From: Martyn White <Martyn.White@arun.gov.uk>
Sent: 24 August 2020 15:00
To: Amber Willard <Amber.Willard@arun.gov.uk>
Subject: BN/62/20/HH

BN/62/20/HH

Construction of a garage space and Gardener's Shed

notes:

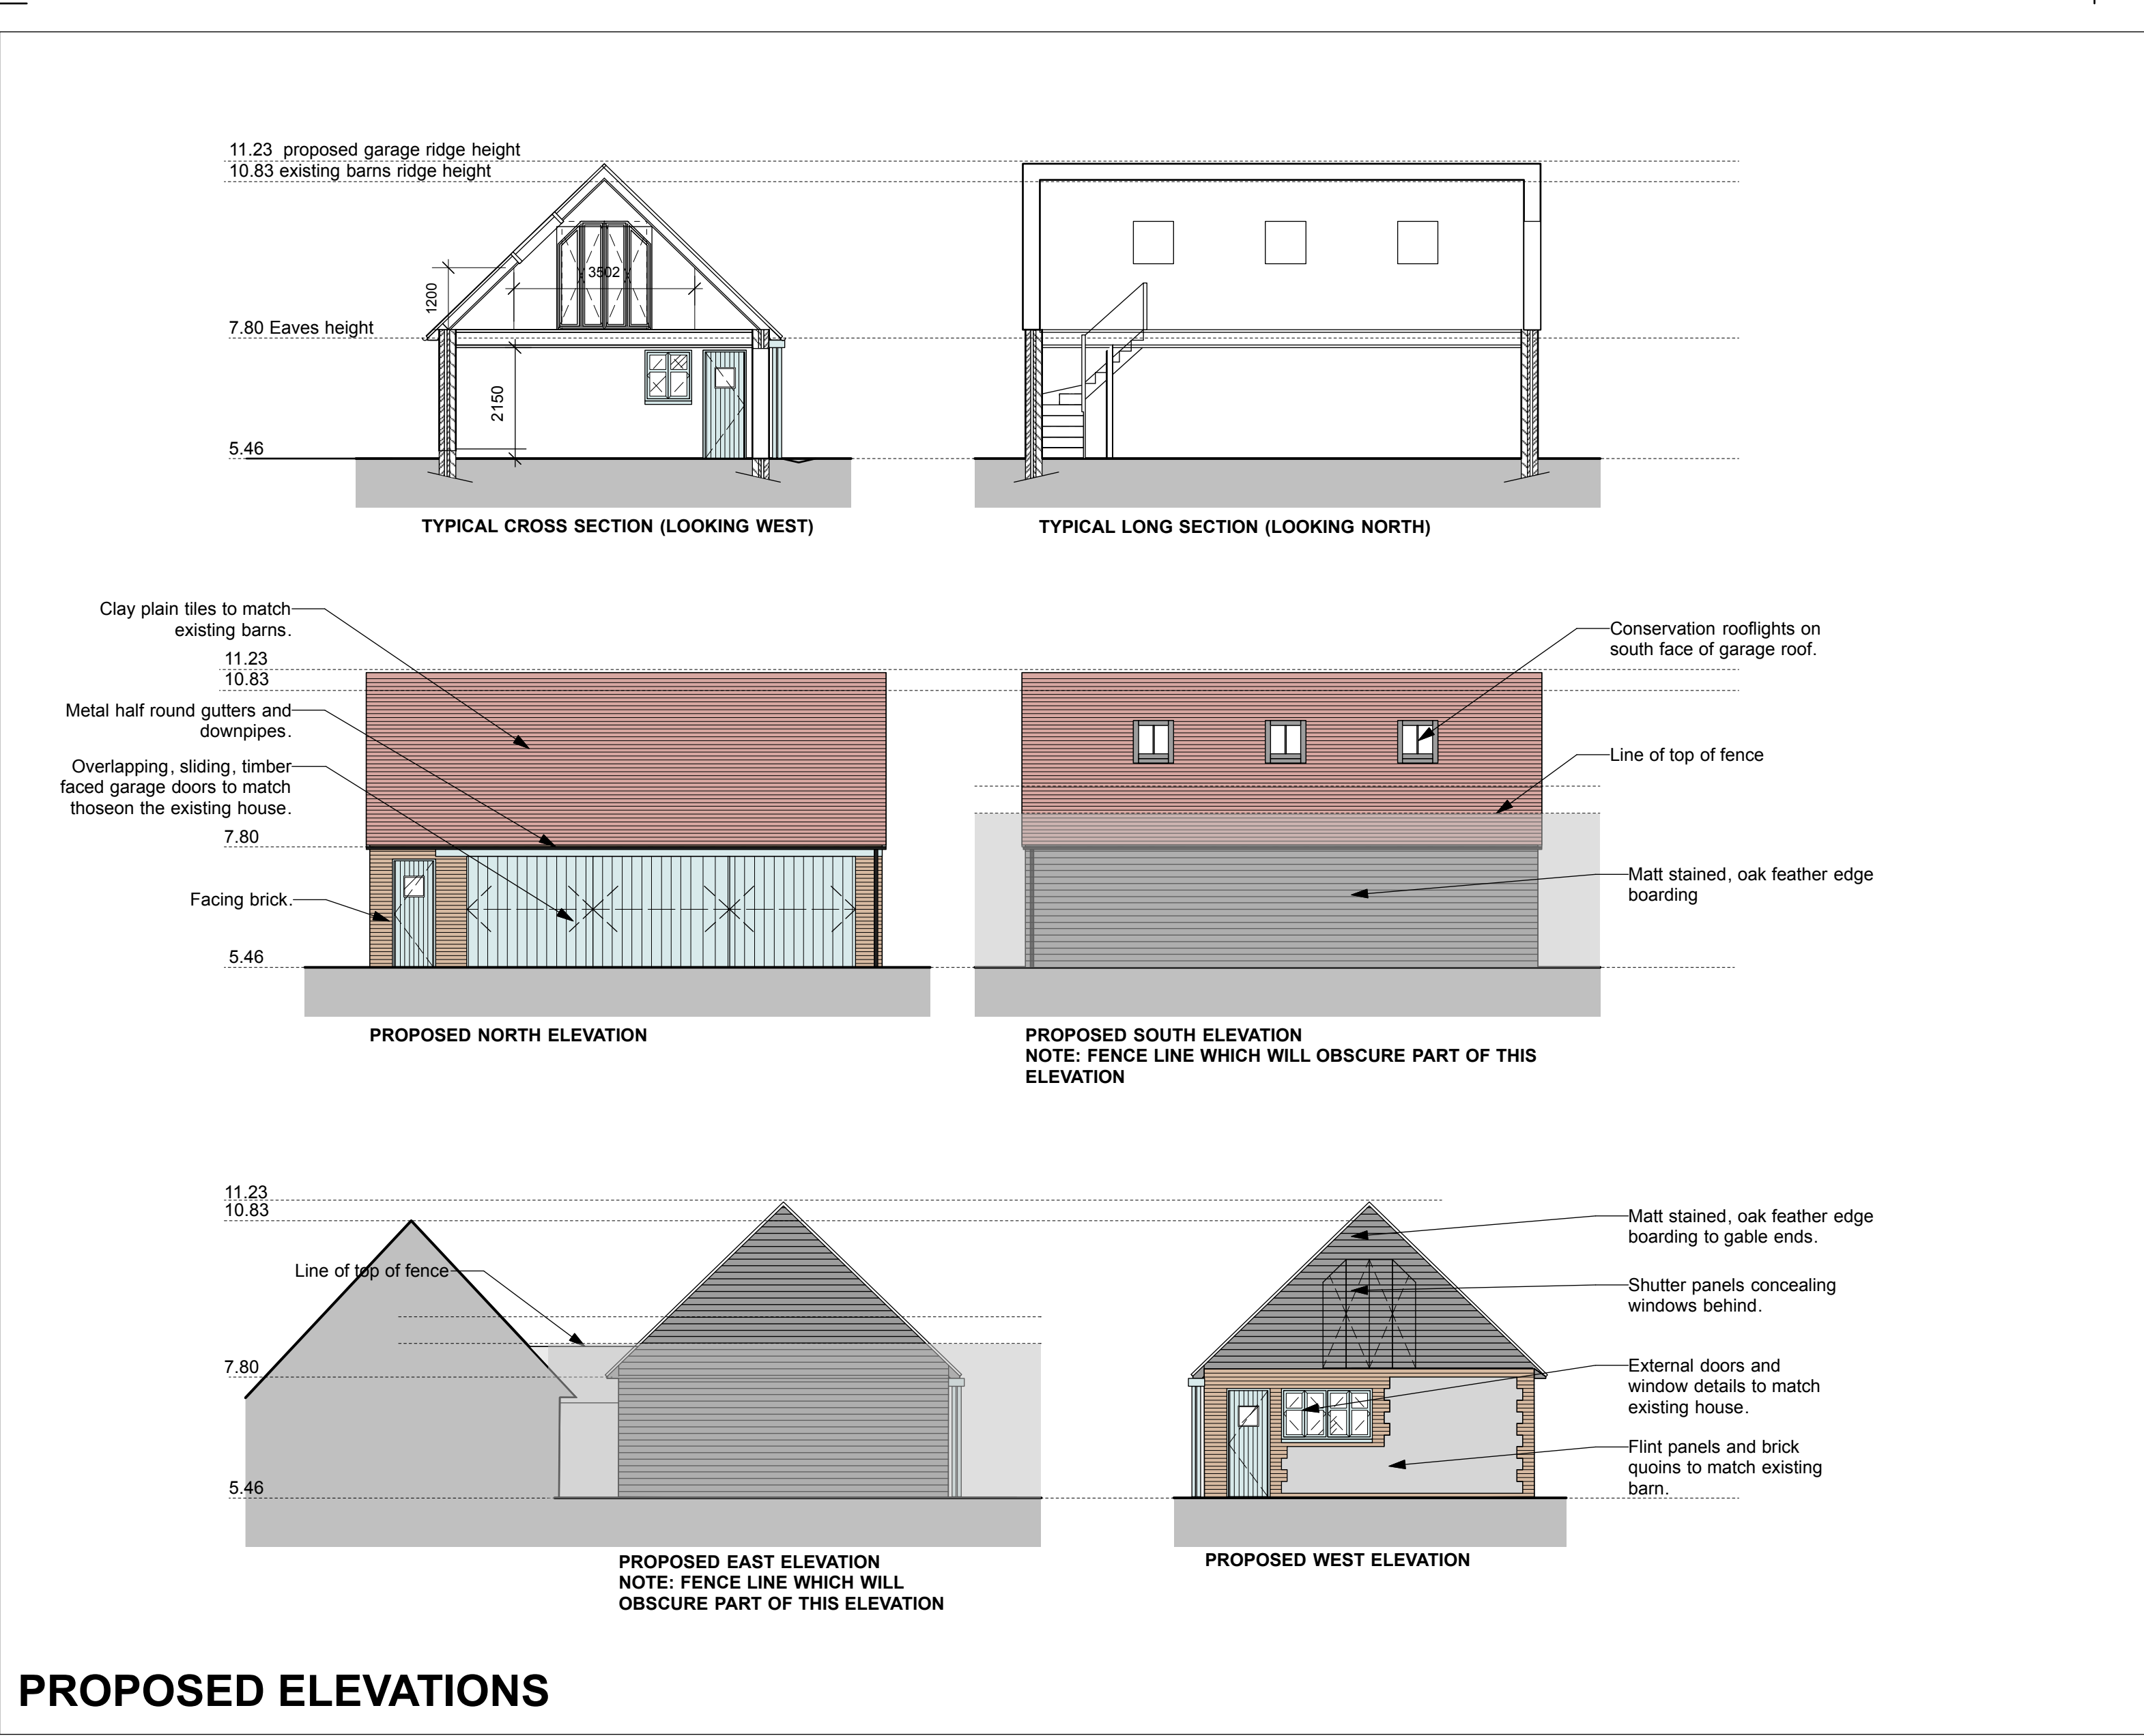
These have a traditional character to them; they appear to have taken reference points from elements of the application site as well as the adjoining former agricultural buildings. Further, they are also of a scale which would reflect the existing former agricultural buildings and would sit acceptably in their location when viewed from other parts of the application site.

Whilst located in close proximity to the listed church, it is suggested that as they reflect the neighbouring buildings, they would form a natural extension to the existing former agricultural building group and not necessarily a new insertion. It is considered that the proposal will not harm the strong relationship between Barnham Court, the parish Church and the farm. Therefore, on balance, they will be acceptable. This is subject to the use of high-quality materials and craftsmanship of any proposed works.

8 JULY 2020
SKETCH DETAILS OF
DOORS / WINDOWS TO
PROSED GARAGE / GARDENERS
SHED

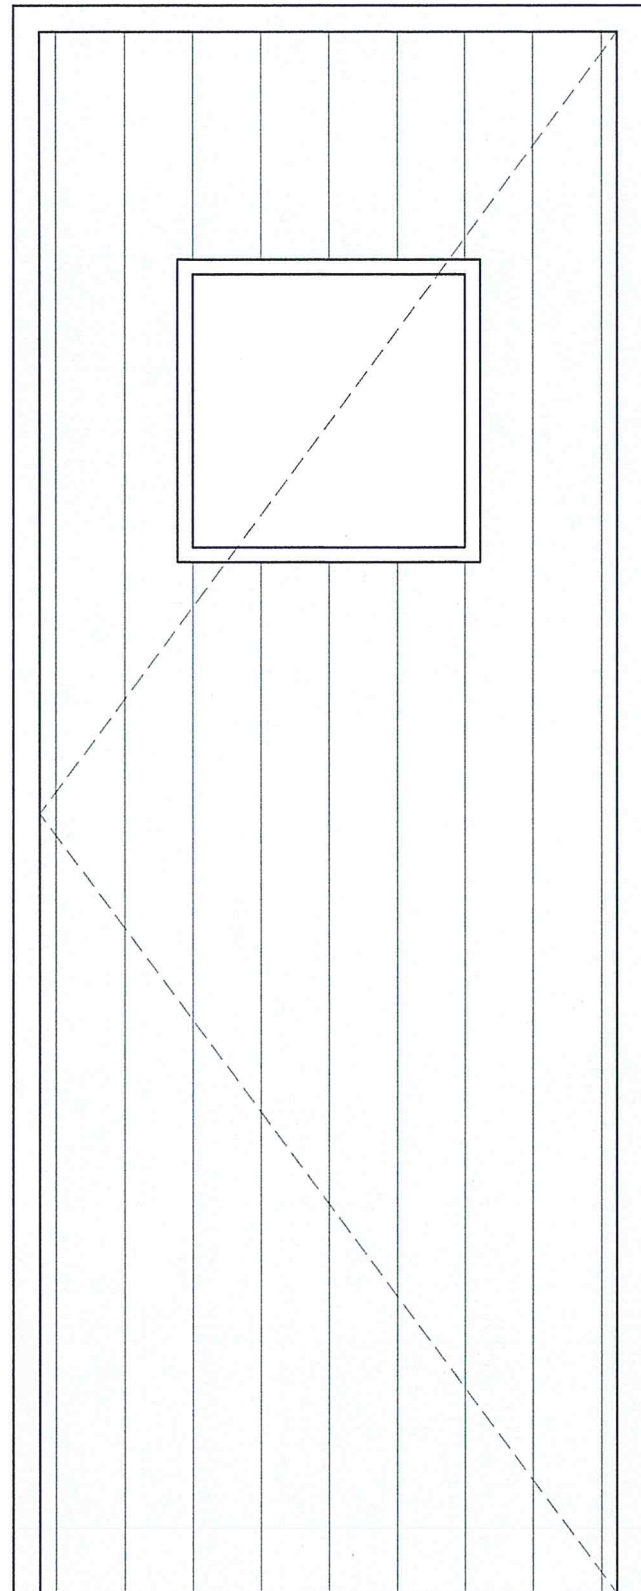
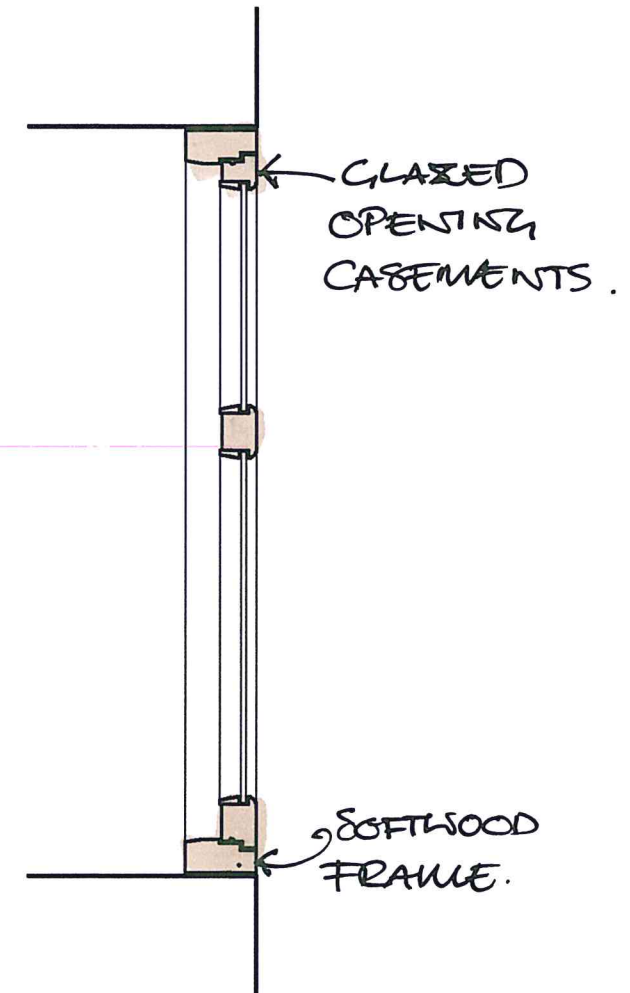
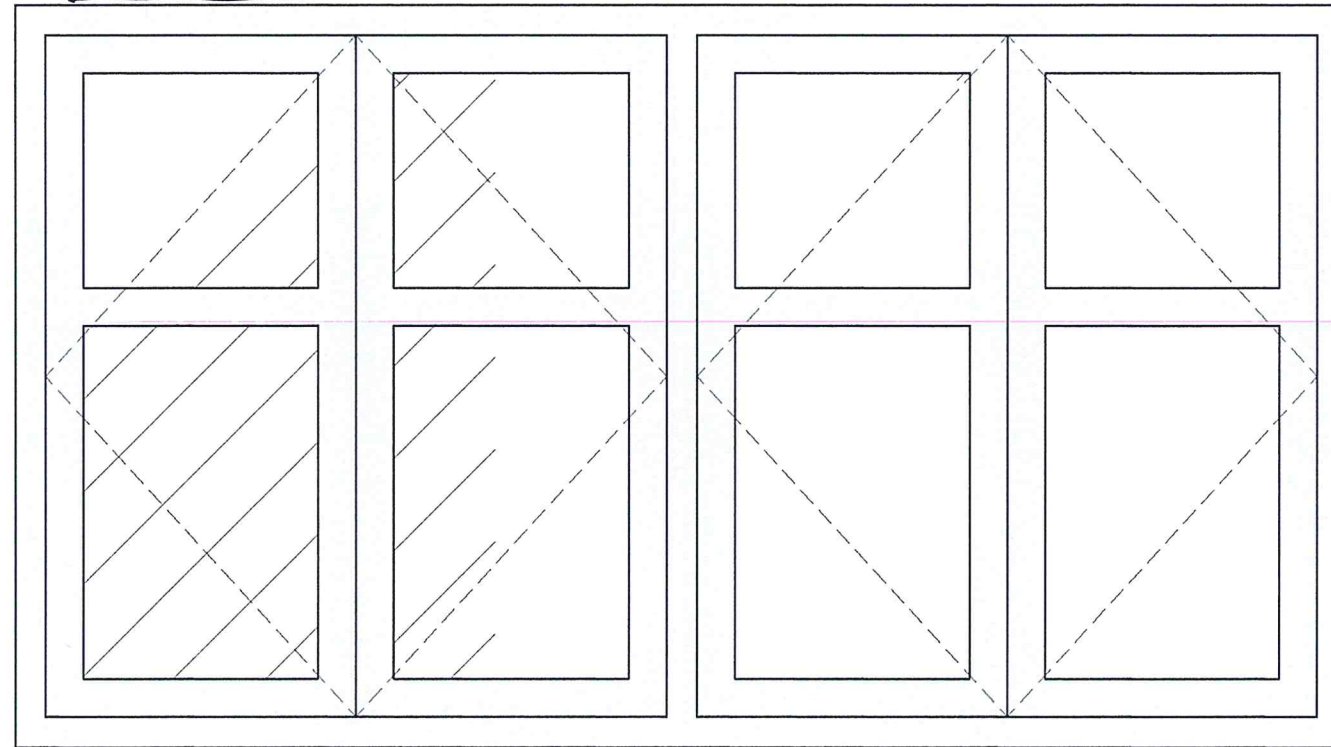
The proposed materials reflect those already used on traditional buildings in the locality, which is positive. Details of the proposed windows and pedestrian door have been provided as part of this application these are considered to be acceptable. Whilst a list of materials have been provided, and these appear to be appropriate for the buildings and local area, it is suggested that you may wish to condition further information should you be minded to approve the application.
